Town & Country Planning Act 1990 (as amended)
Town & Country Planning (Development Management Procedure) (England) Order 2015
Application for Planning Permission for Works or Extension to a Dwelling

Development Demolition of existing open porch and construction of new extension to provide an enclosed porch and accessible WC.

Location Bersted Manor 350 Chichester Road Bersted

PROPOSED BLOCK PLAN - Scale 1:500

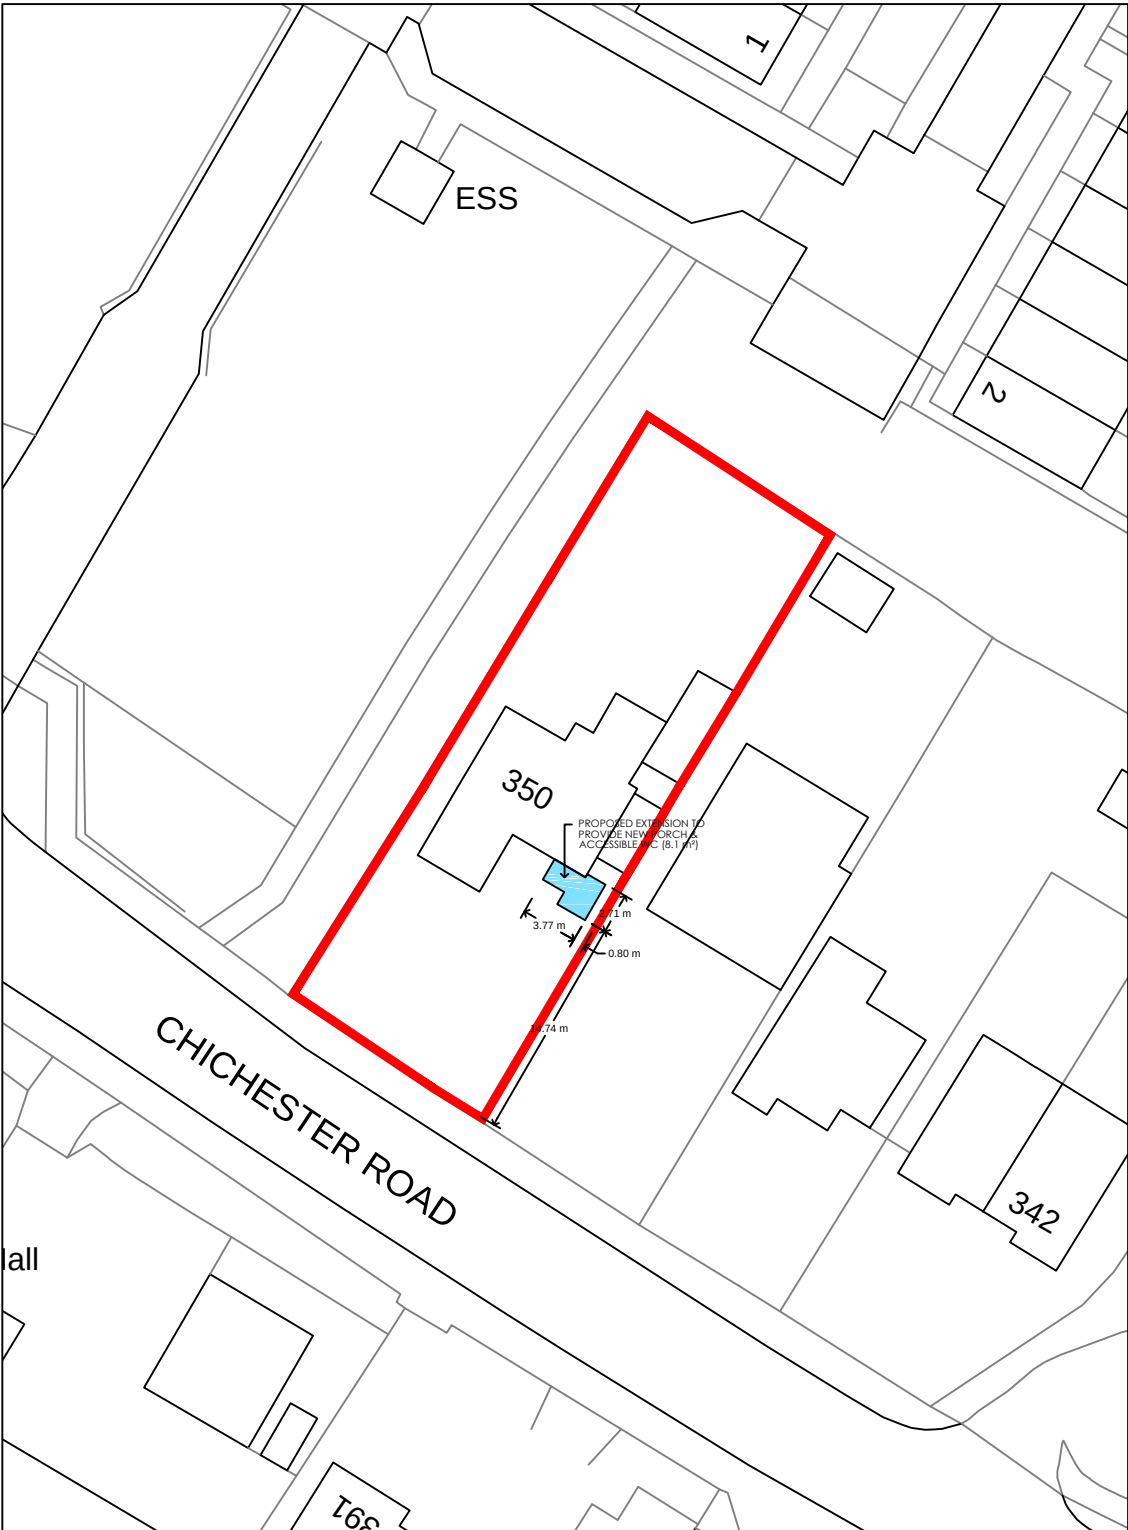
Block Plan: The proposed extension needs to be shown on the block plan and dimensions to the site boundaries needs to be included.
